Our Ref: R/130/19/PL

Town & Country Planning Act 1990 (as amended)
Town and Country Planning (Development Management Procedure) (England) Order 2015
Application for Full Planning Permission

Development Application for variation of a condition following grant of planning permission
R/190/18/PL relating to condition no.2 - amended access points
Location St Marys Close Hurst Road Rustington

ADDITIONAL 2 DWELLINGS
BLOCK/ SITE PLAN

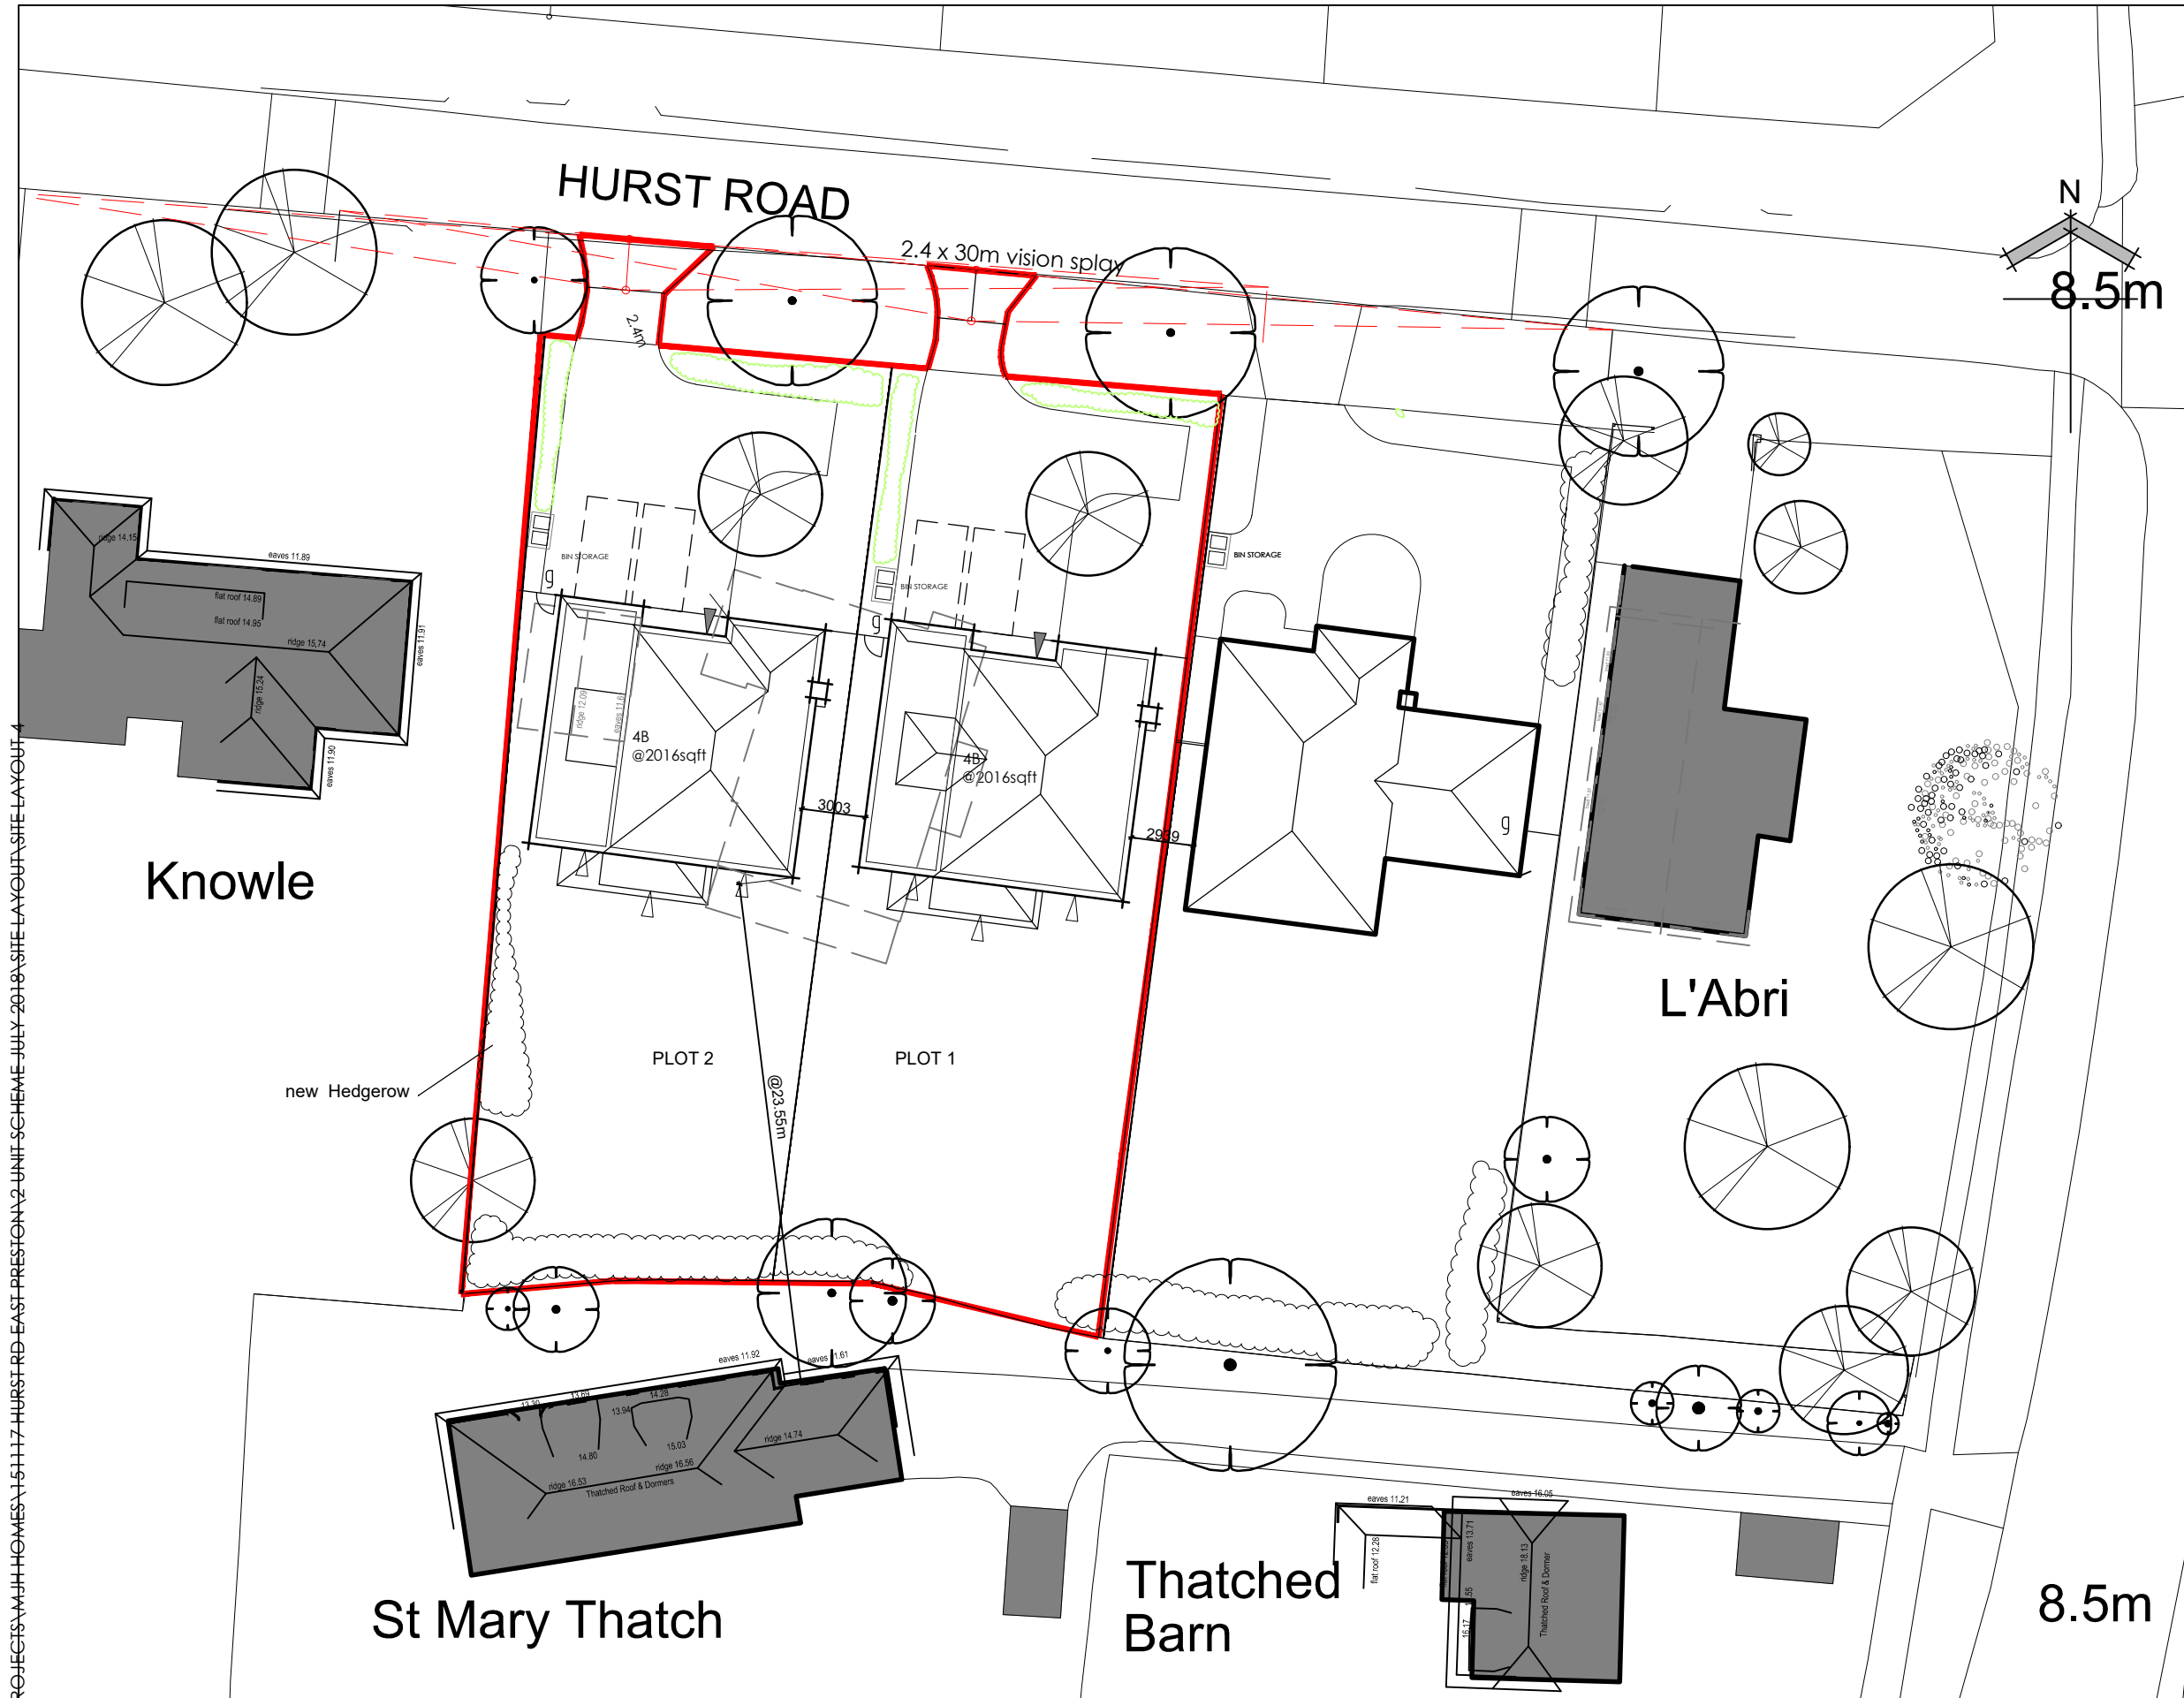
The location and block plans must include the access points and visibility spays within the site area as per the guidance notes available online. Please therefore forward amended plans to include this area within the red edge
